CITY OF ALBUQUERQUE

May 23, 2016

**Re: Independence Square
Erosion and Sediment Control Plan
Engineer's Stamp Date plan 2-5-16, 5-23-16 detail sheet 5-23-16 (E17E076)**

OUTLET (PERSPECTIVE)
TEMPORARY SEDIMENT TRAP (ST)
N.T.S.

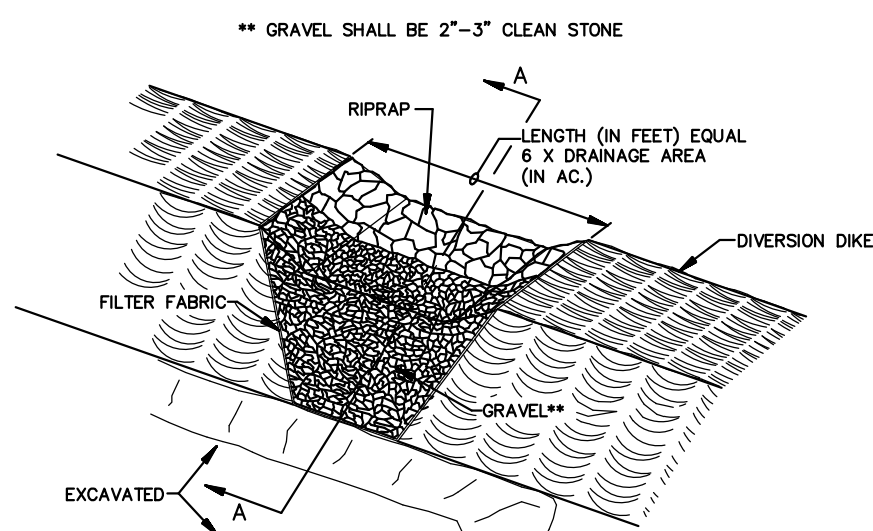
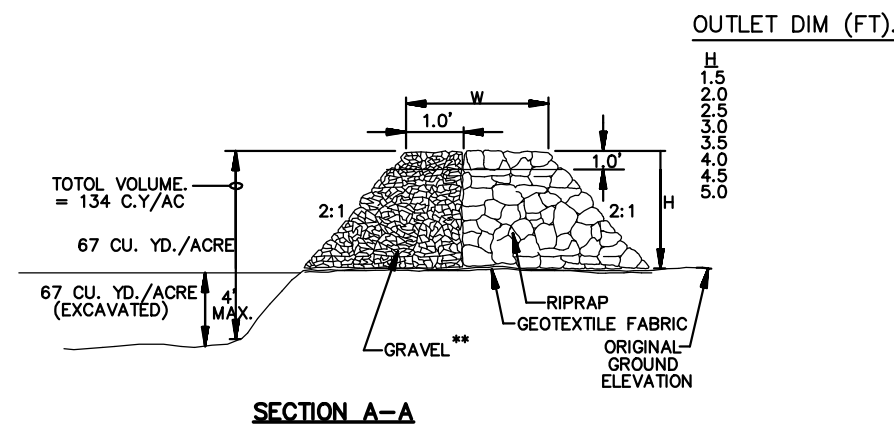
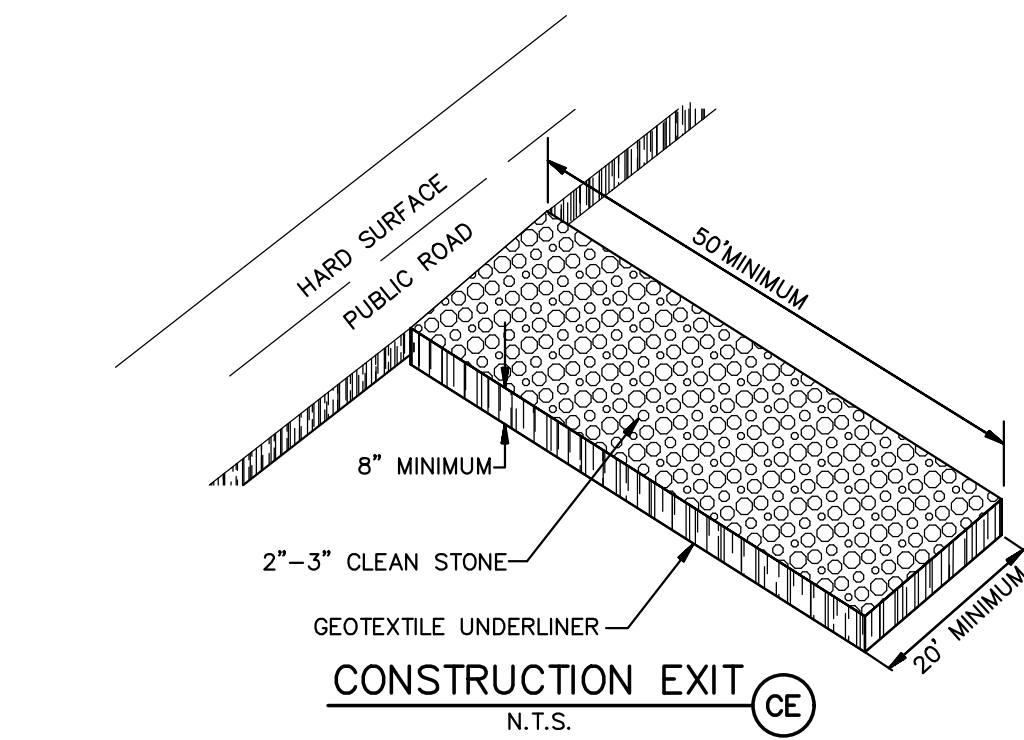
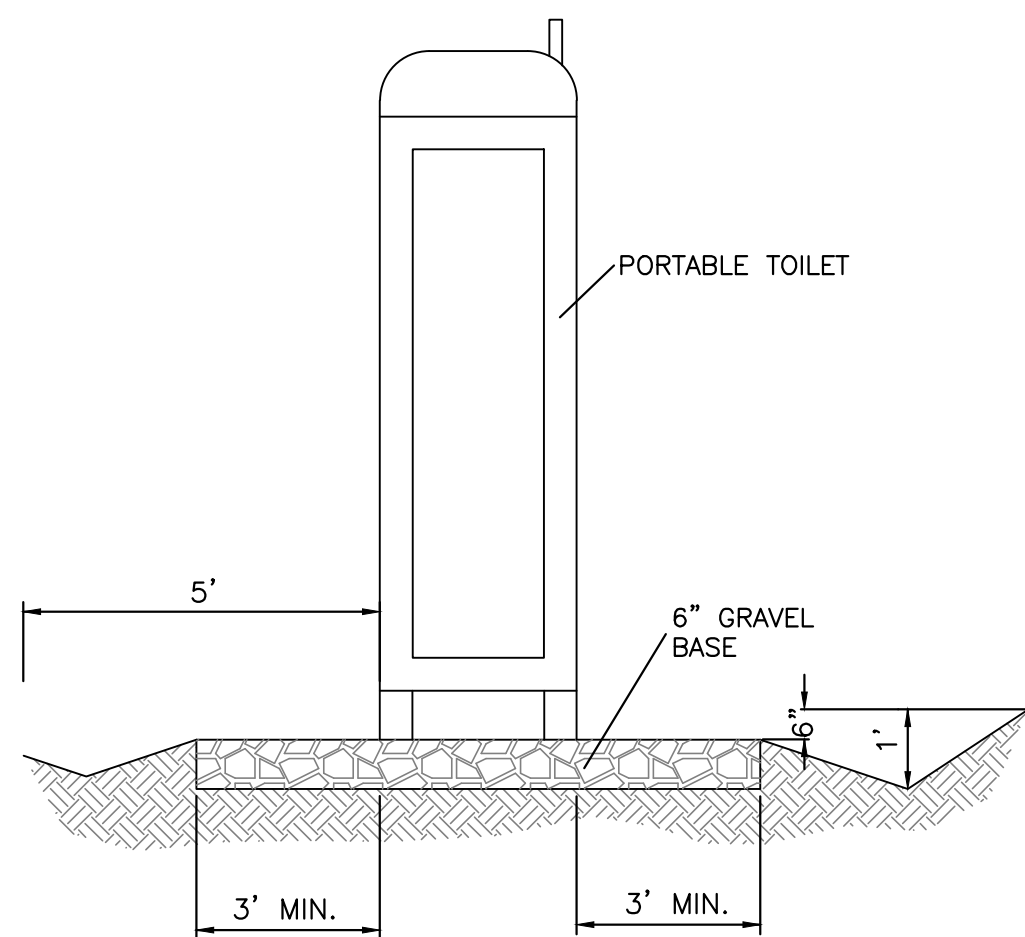
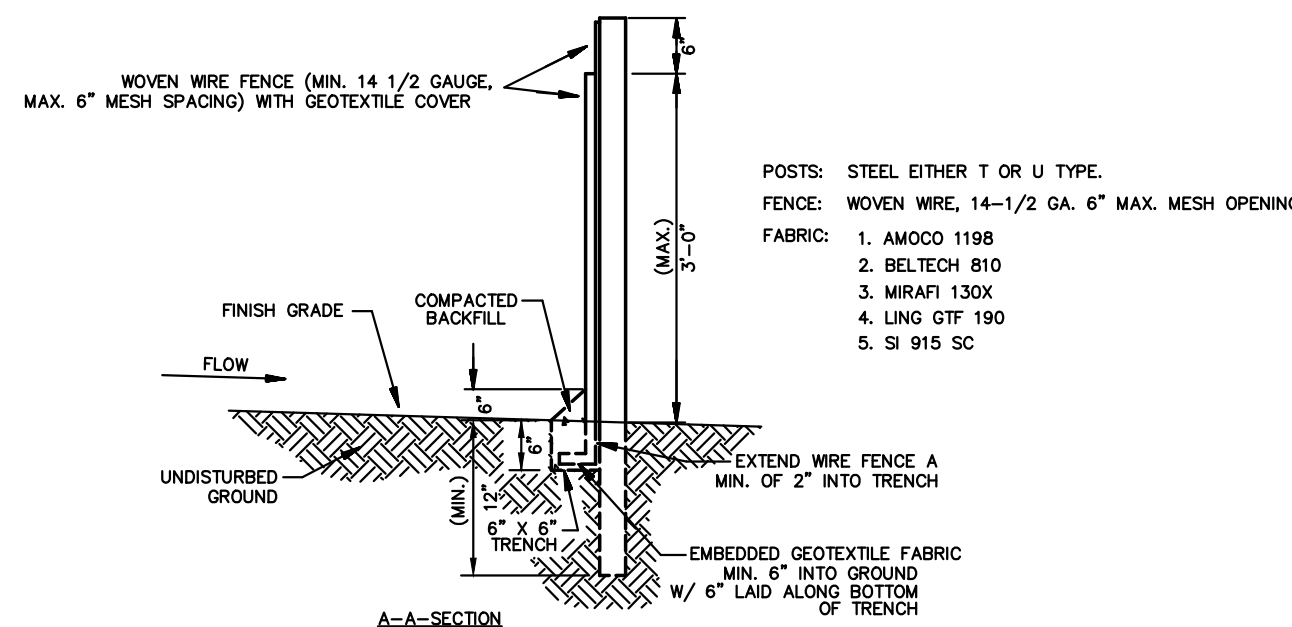
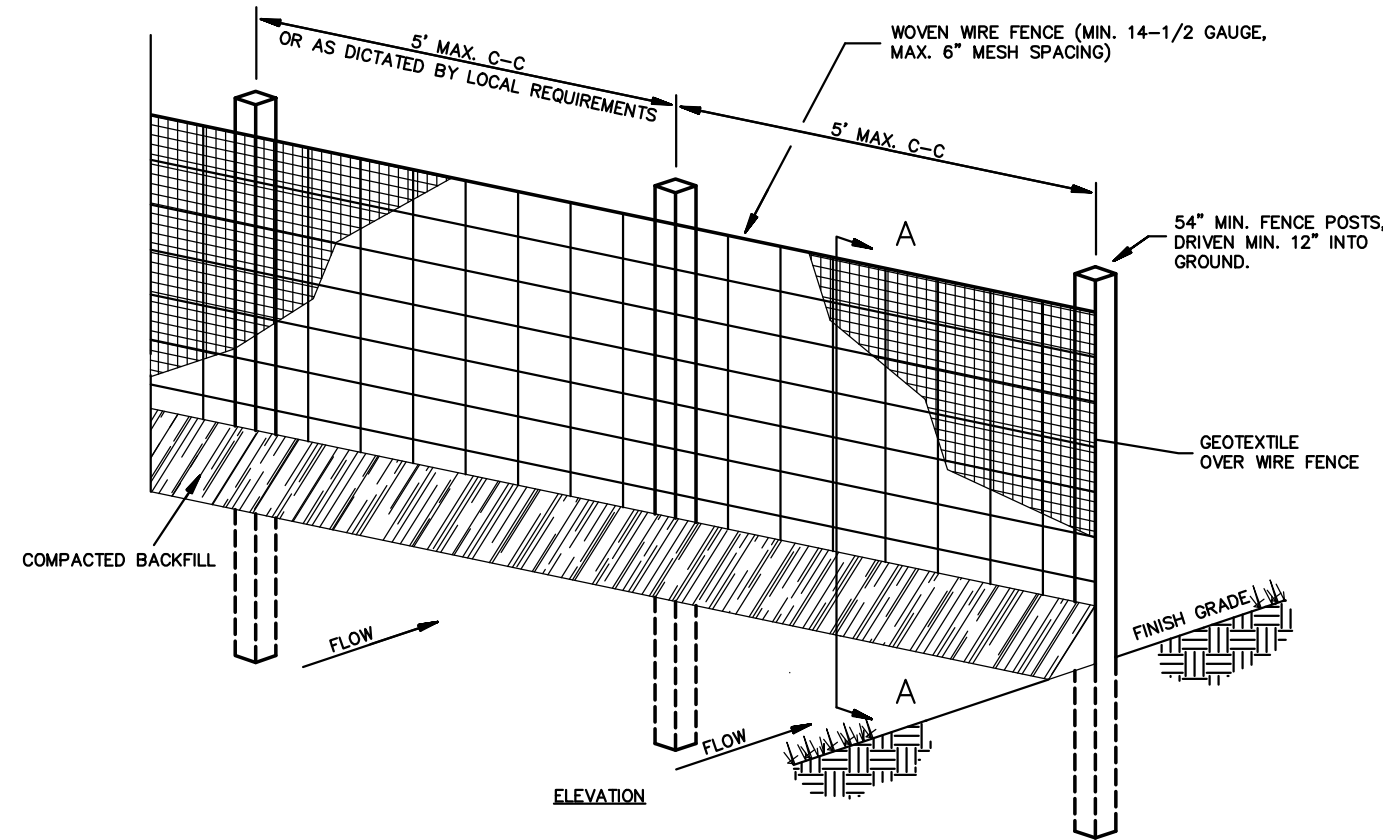
1. It is understood that the legend item for "Proposed Storm Inlet" implies inlet protection. Please clarify on future submittals.
2. The outlet for the pond has a sediment BMP.
